April 21, 2014

**Subject: 421 Warren Avenue
Preliminary Level III Site Plan Application
Response to Peer Review Comments**

We have received and reviewed Woodard & Curran's peer review comments dated March 3, 2014 and Tom Errico's comments dated March 12, 2014 regarding the Preliminary Level III Site Plan Application for the 421 Warren Avenue Commercial Complex project. We offer our responses to these comments. For ease of reference we have repeated each comment in *italics* followed by our response.

SEE SCHEDULE B

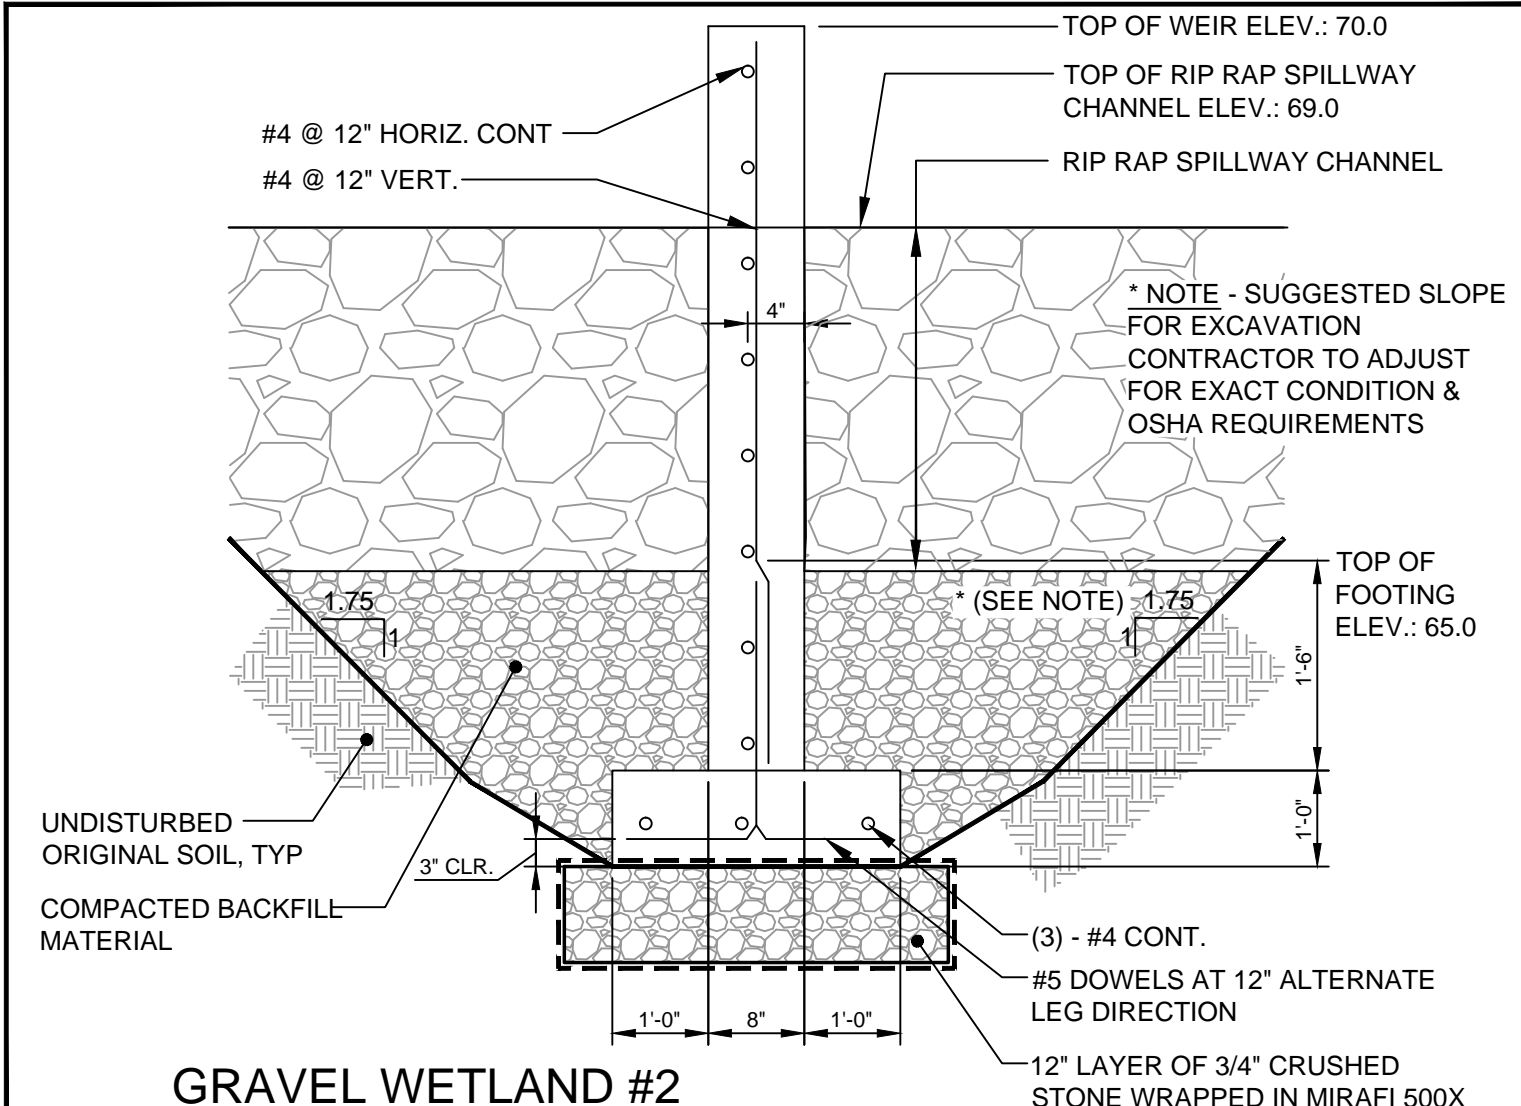
e) As noted on the plans, the Applicant intends to add outlet elevation information to the outlet control structure details for both gravel wetlands as part of the final submittal. Without this information we cannot verify the routing or model inputs for Pond 4P (GW2) or Pond 5P (GW1). When the outlet control structure elevations are incorporated into the final submittal, please revisit or provide explanation on the routing methodology for GW1 & GW2 in the HydroCAD model; we are unable to follow the routing as currently presented.

b) The Applicant has submitted drawdown calculations for sizing the gravel wetlands' outlet control structure orifice control devices; however, the orifices do not appear to be specified on the design plans/details. The Applicant should clarify with the final design package.

The Applicant has added outlet control structure to the plans and details. Refer to Sheet C-4.3, Detail E for an updated elevation schedule.

Orifice sizes and locations have been added to outlet control structure details on Sheet C-4.3. Orifice details correspond to drawdown computations submitted in Appendix E.
